Date: 07-Jul-2023
Our Ref: 2023/91469

**TOWN AND COUNTRY PLANNING ACT 1990
TOWN AND COUNTRY PLANNING (GENERAL PERMITTED DEVELOPMENT)
(ENGLAND) ORDER 2015 (as amended), SCHEDULE 2, PART 3, PART MA
NOTIFICATION OF PROPOSED CHANGE OF USE CLASS MA – COMMERCIAL,
BUSINESS AND SERVICE USES TO DWELLINGHOUSES
APPLICATION NUMBER: 2023/91469
AT: 2, 4 & 6, Thornton Lodge Road, Thornton Lodge, Huddersfield, HD1 3JQ**

Prior approval of a proposed change of use of a building from commercial, business and service uses to dwellinghouses

DWG NO. 2304 - 02

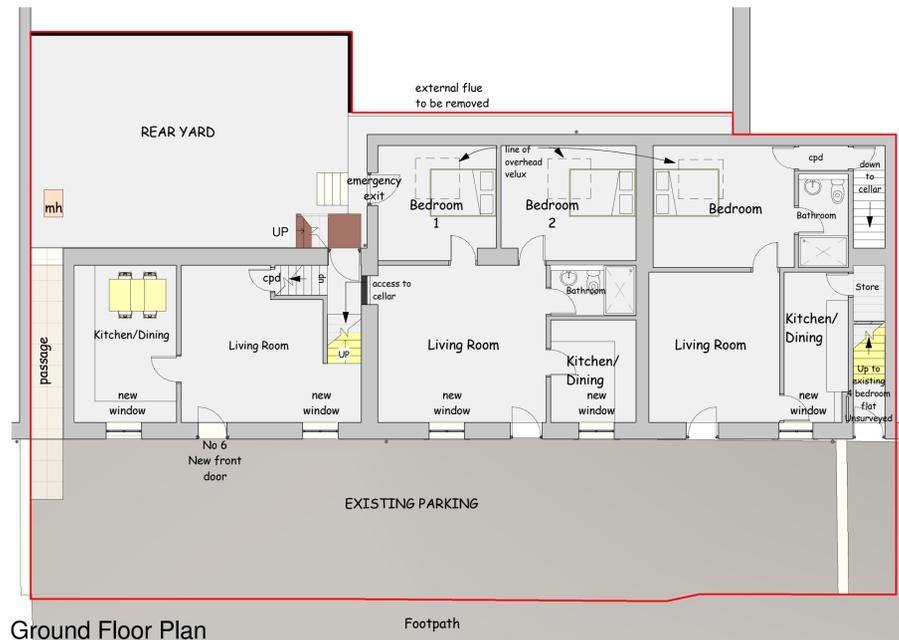
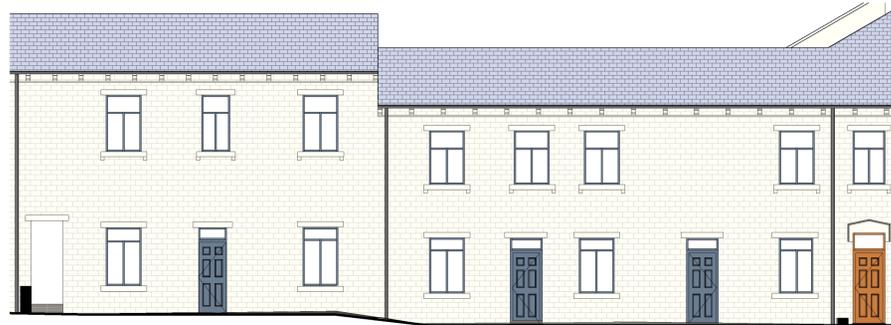
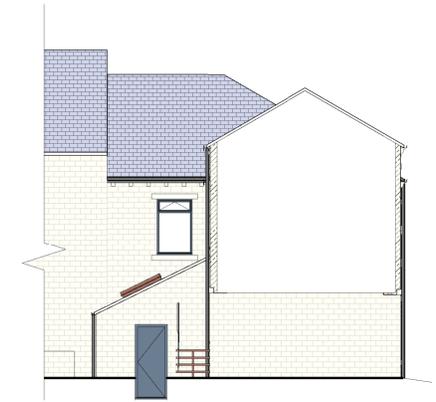
No. 2 is proposed to be a one bedroom ground floor flat. The Technical Housing Standards document states that a one bedroom flat for one person (minimum assessed) on one storey should be at least 37 or 39 square metres dependant on whether the bathroom has a shower or a bath. In this instance the proposed internal accommodation proposed is approximately 48 square metres which may accord with the recommended space standards. However, the bedroom is shown to sleep two persons which requires 50 square metres of space thus contrary to space standards.

No. 4 is proposed to be a two bedroom ground floor flat. The Technical Housing Standards document states that a two bedroom flat for three persons over one storey (minimum assessed) should be at least 61 square metres and for four persons 70 square metres. In this instance the proposed internal accommodation proposed would be approximately 56 square metres and therefore falls short of the recommended space standards and therefore cannot benefit from a prior approval.

No. 6 is proposed to be a 2 no. bedroom property over two storeys. The Technical Housing Standards document states that a two bedroom property for three persons over two storeys (minimum assessed) should be at least 70 square metres. In this instance the proposed internal accommodation would be approximately 71 square metres. Whilst this would meet the standards set for 3 persons, it falls short acceptable space for 4 persons which would require a minimum of 79 square metres. Provided that a maximum of three persons reside at the property, the proposal would accord with the recommended space standards

The external alterations as shown on the proposed plan for no.2 & no.4 do not benefit from any planning permission and the provision set out in Class MA, Part 3 of Schedule 2 of the Town and Country Planning (General Permitted Development)(England) Order (as amended) do not provide for such permission either. Consequently the assessment of natural light is taken under current fenestration arrangements for each proposed dwellinghouse. Therefore all bedrooms in no. 2 & no.4 lack any natural light and are therefore contrary to paragraph MA.2 (2)(f) of Class MA.
